Consultation Response from KC, Lead Local Flood Authority
2023/93704 land northwest of, Urban Terrace, Denby Lane, Grange Moor, Huddersfield, WF4 4EB
Erection of 12 dwellings and associated works
Date Responded: 30th December 2024 Responding Officer: Paul Farndale Responding Ref:

Further to our comments of 15th November 2024, we urgently require a meeting with the planning officer with regard to where progress has and has not been made subsequently. Our OBJECTION remains.

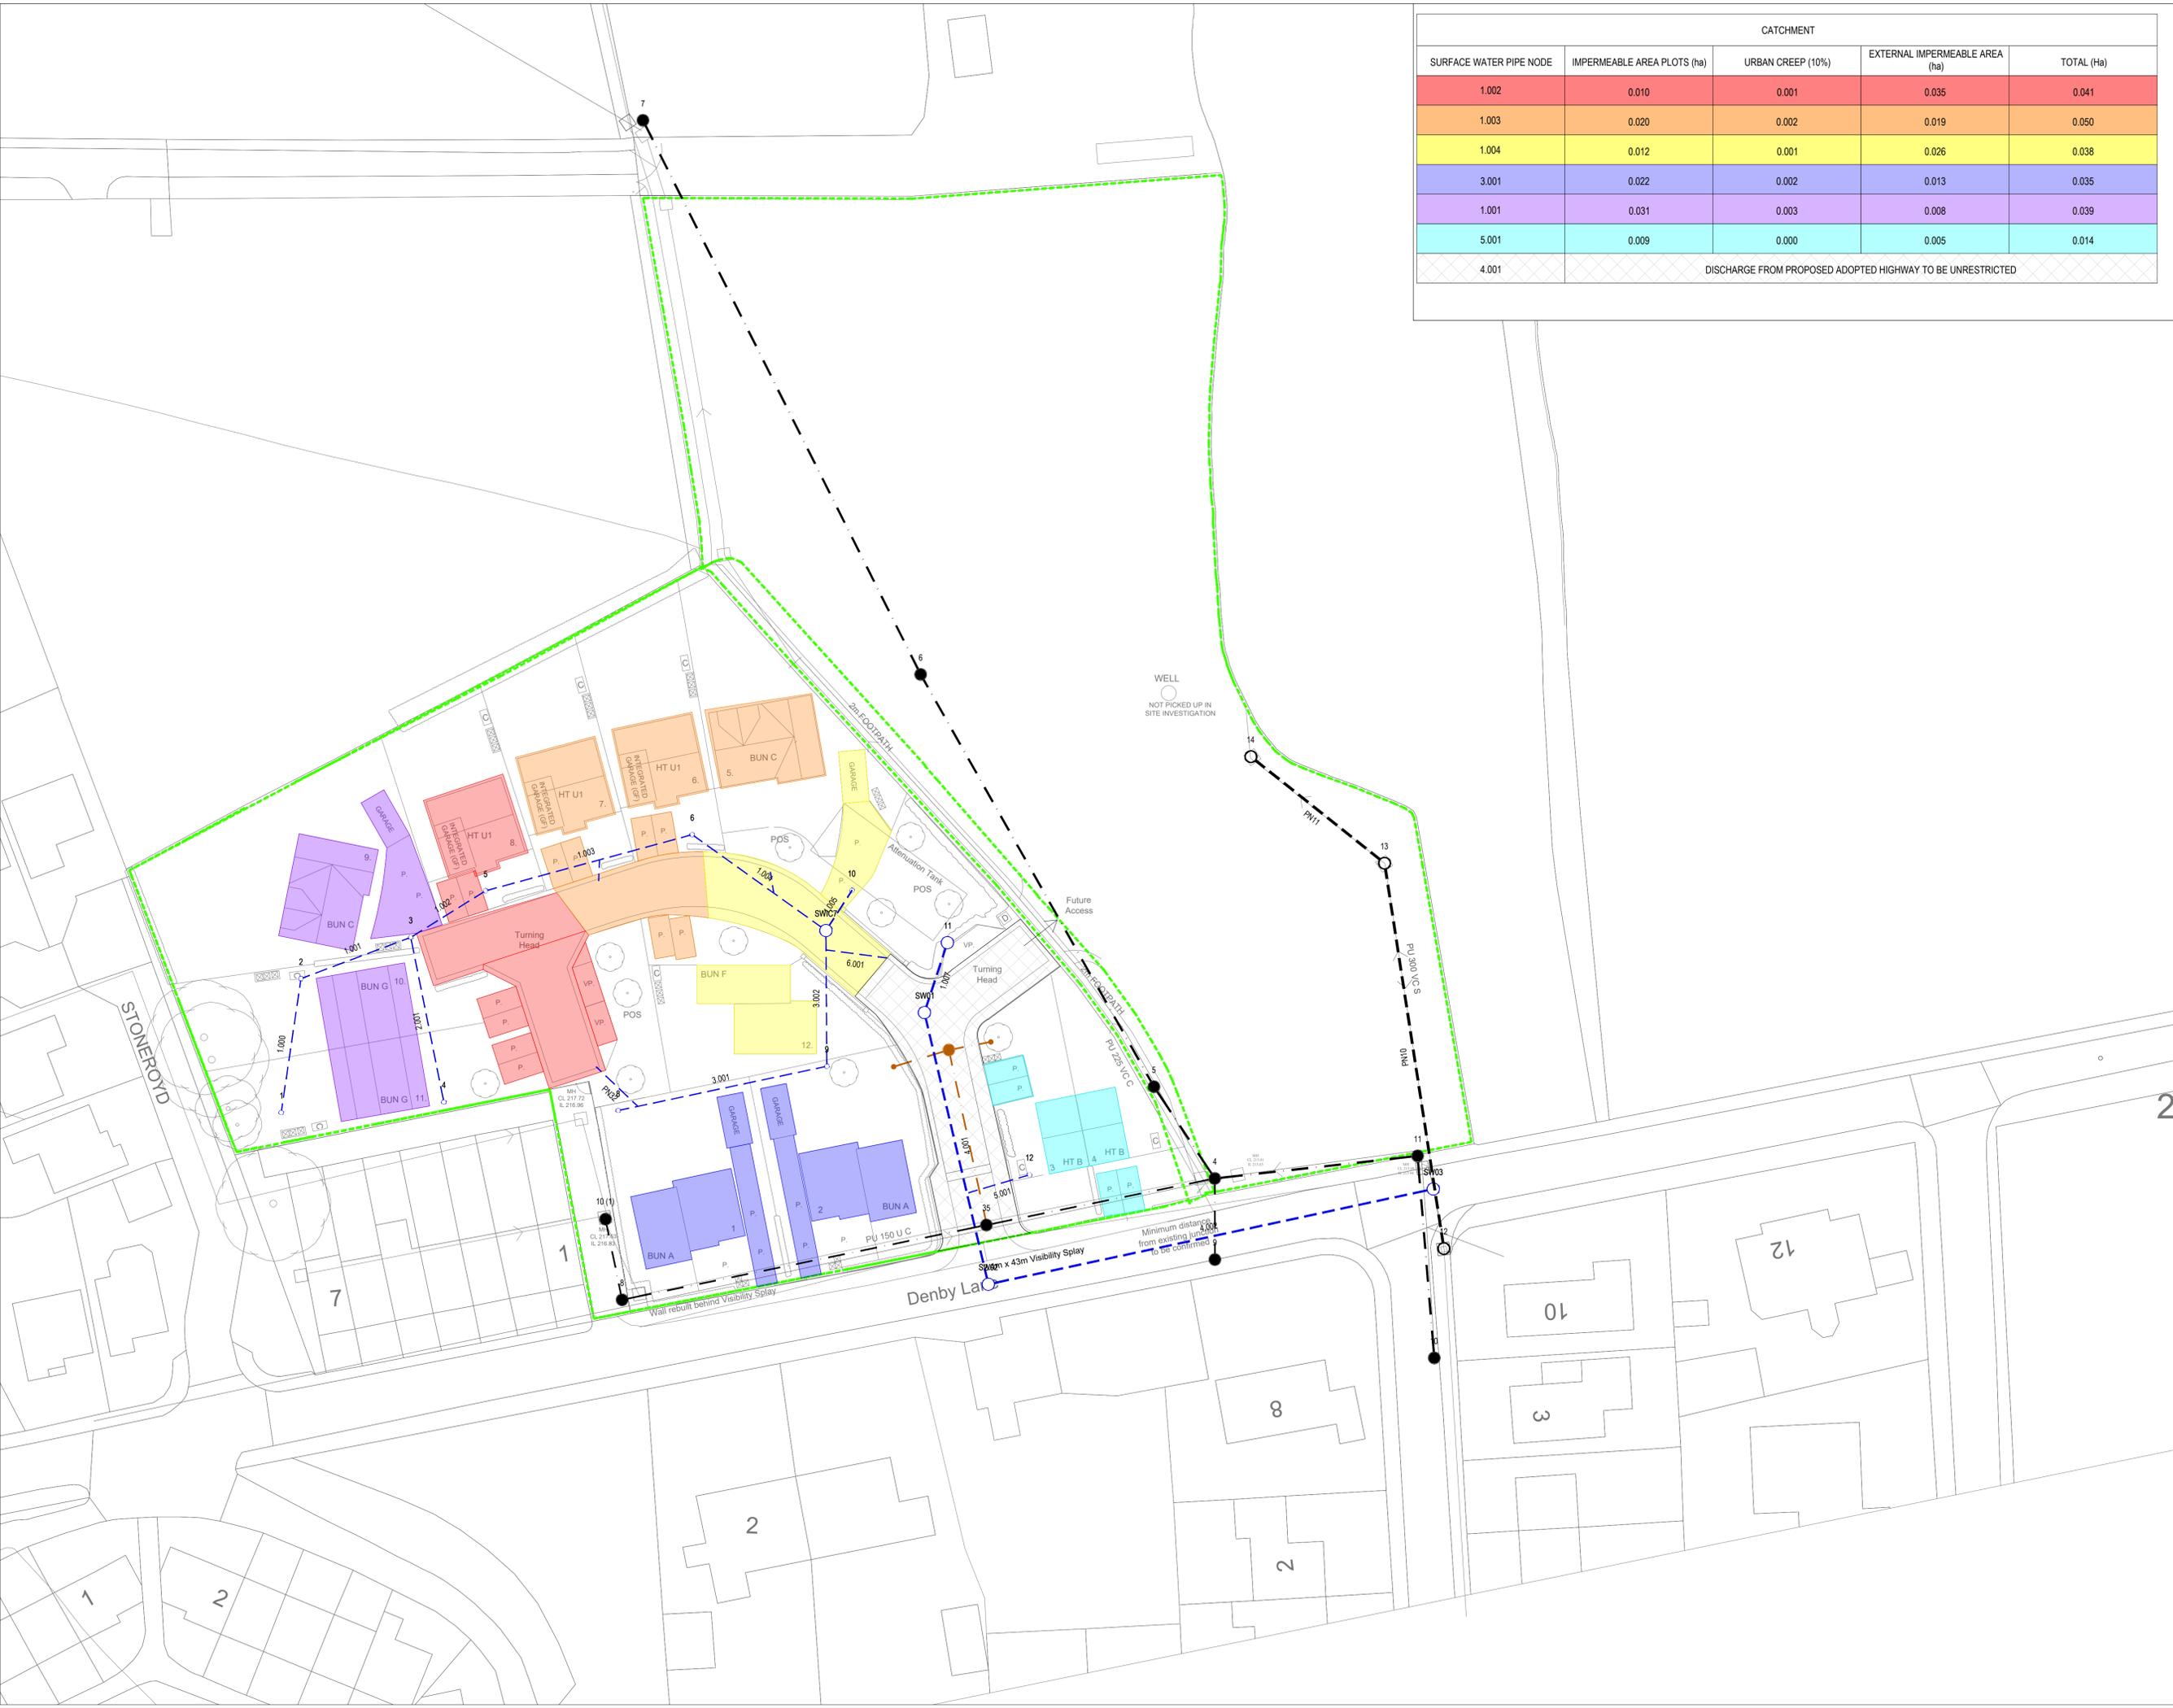
An altered drainage system appears to have potentially solved the issue of discharge rates above 3.5l/s but simulation wizards for a series of summer and winter rainfall events is still required.
